**Addendum No. 2**

RE: Contract ID C202556

**Macon County (R-4748)**

New Route From SR-1660 (Siler Road) To SR-1662 (Wiley Brown Road)  
South of US-441 In Franklin

REVISIONS						SHEET NO. S-25
NO.	BY:	DATE:	NO.	BY:	DATE:	
1			3			TOTAL SHEETS 44
2			4

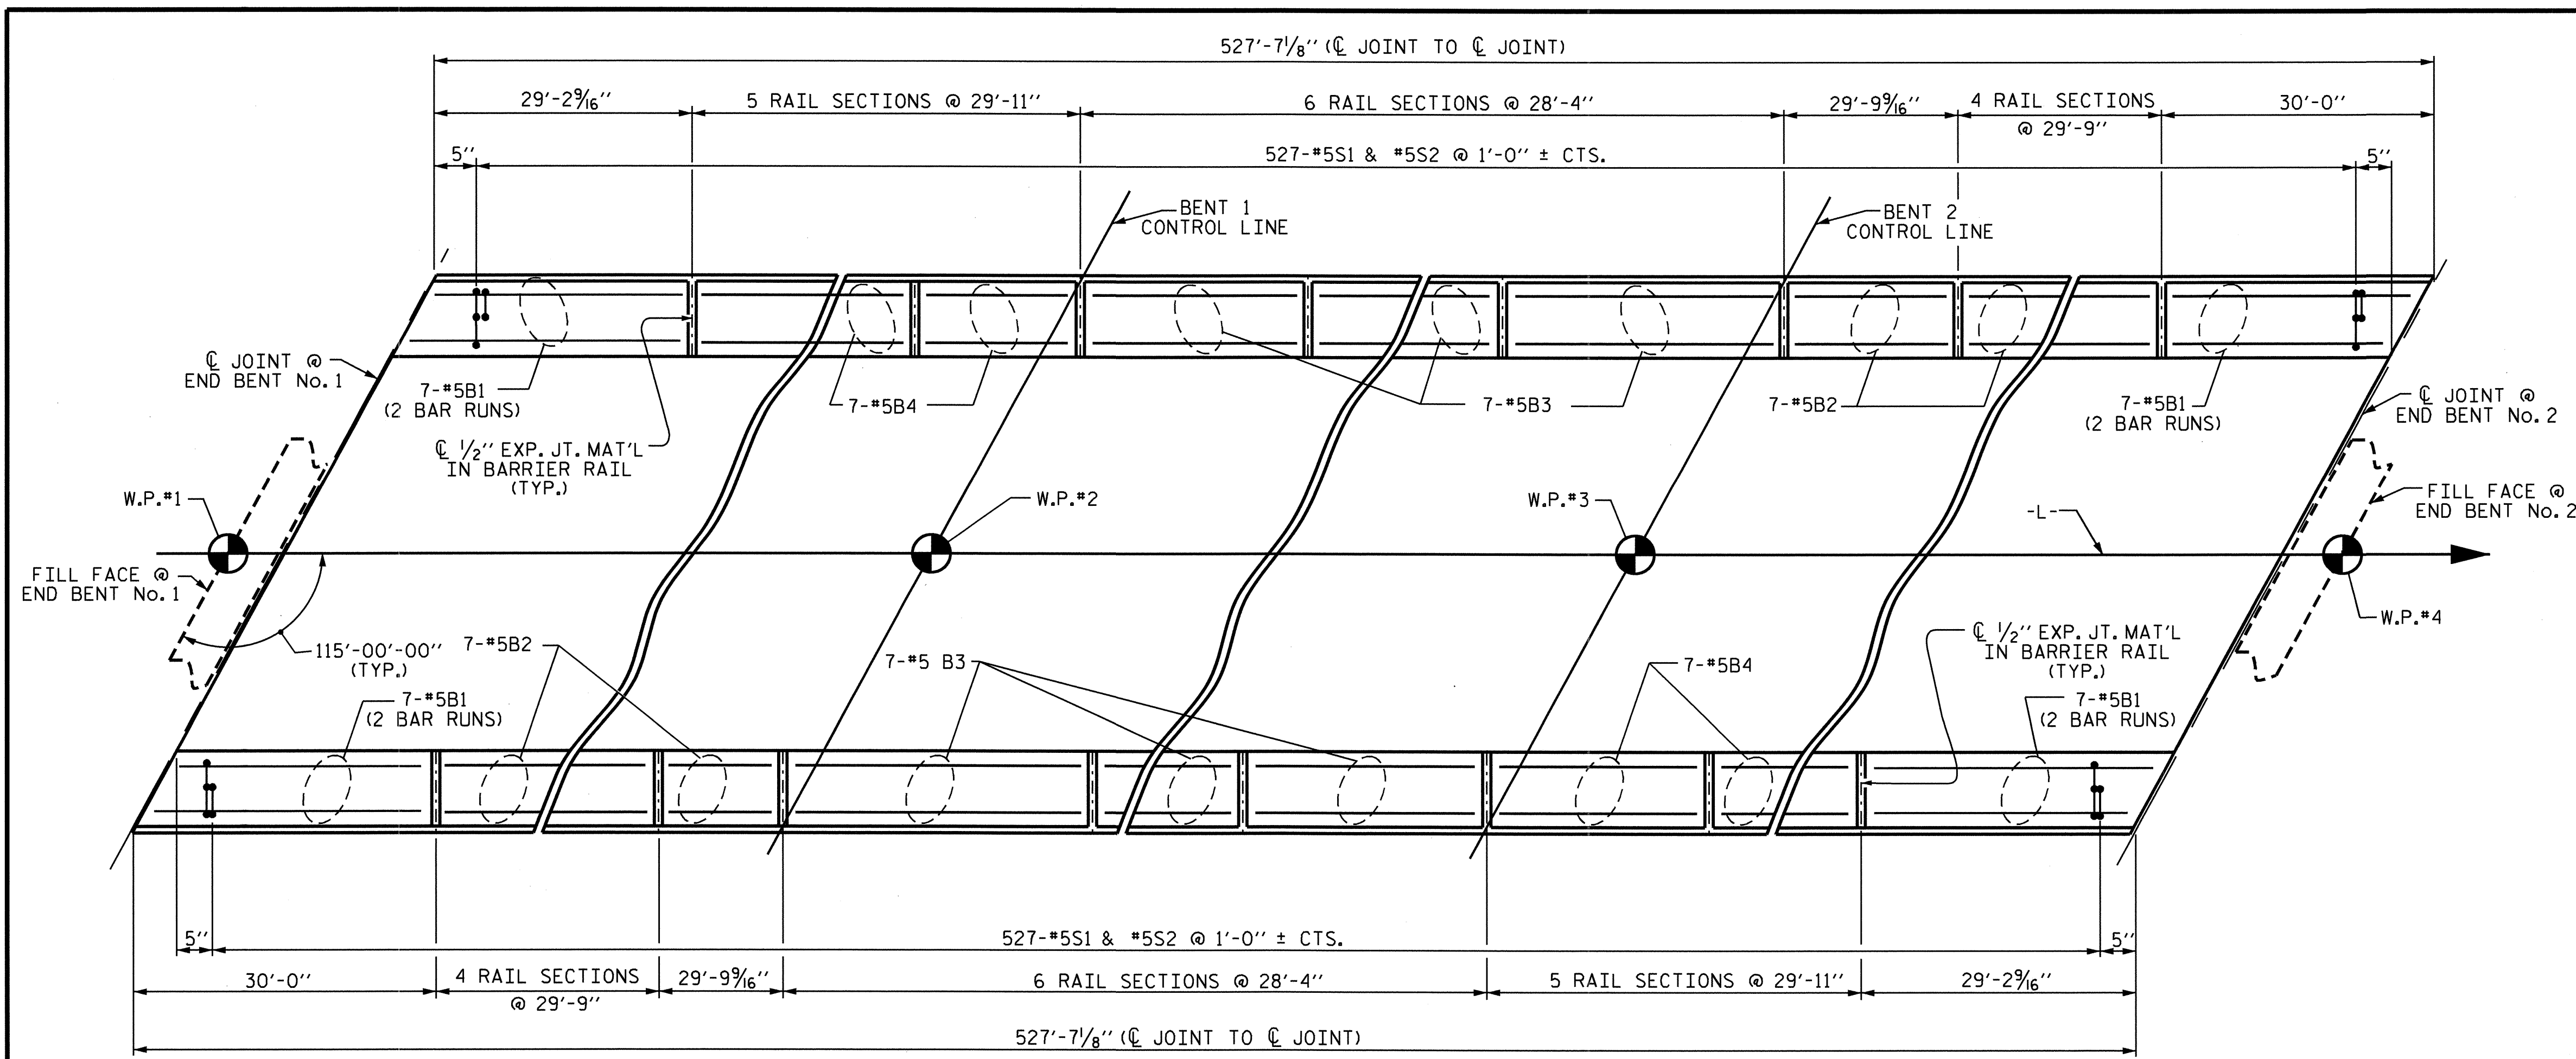
On Sheet No. S-25 the table for "Loads and Movements" has been revised. Please void Sheet No. S-25 in your plans and staple the revised Sheet No. S-25 thereto.
